DRAINAGE INFORMATION SHEET

CITY ADDRESS: 3320 SAN PEDRO NE

OWNER: FIRST CHURCH OF RELIGIOUS SCIENCE CONTACT: _____

DATE SUBMITTED: 4-14-1992

FIRST CHURCH OF RELIGIOUS SCIENCE
 ORIGINAL AND NEW PARKING LOT GRADES
 APRIL, 1992

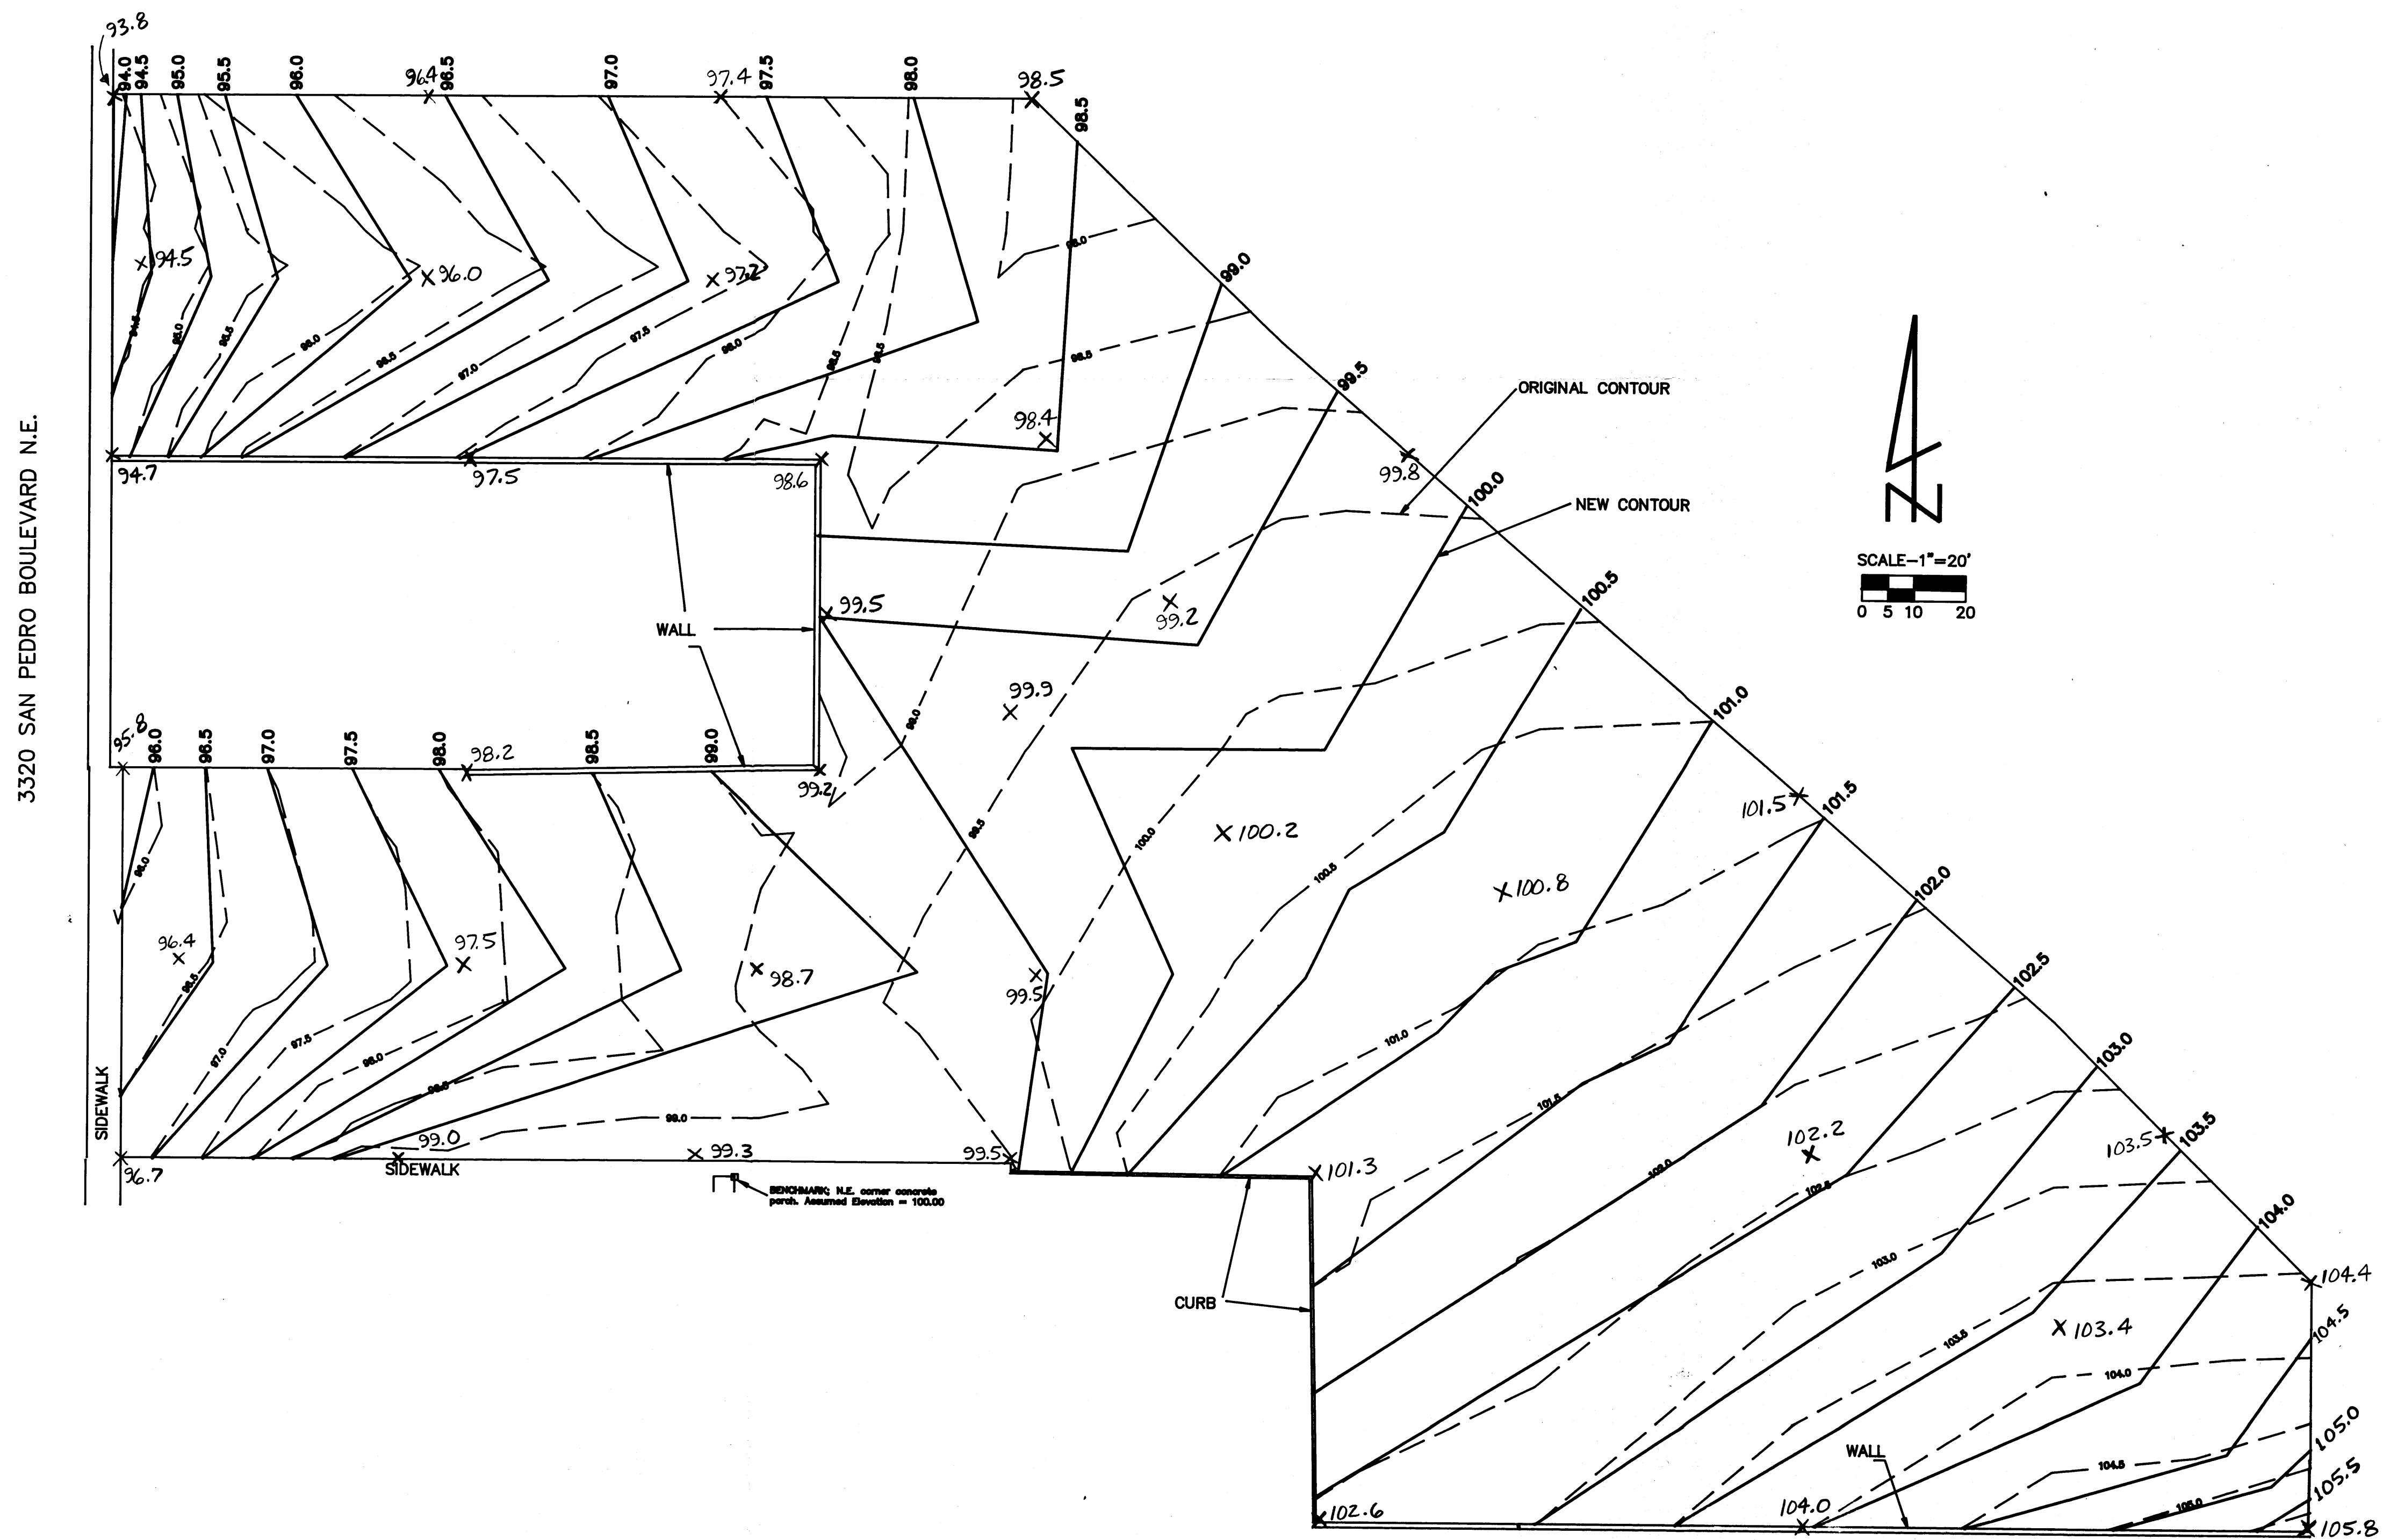
This submittal is incomplete.

Needs the following:

- # 9 address to reach eng.
- legal description on drawings
- vicinity map on drawing
- more complete information sheet
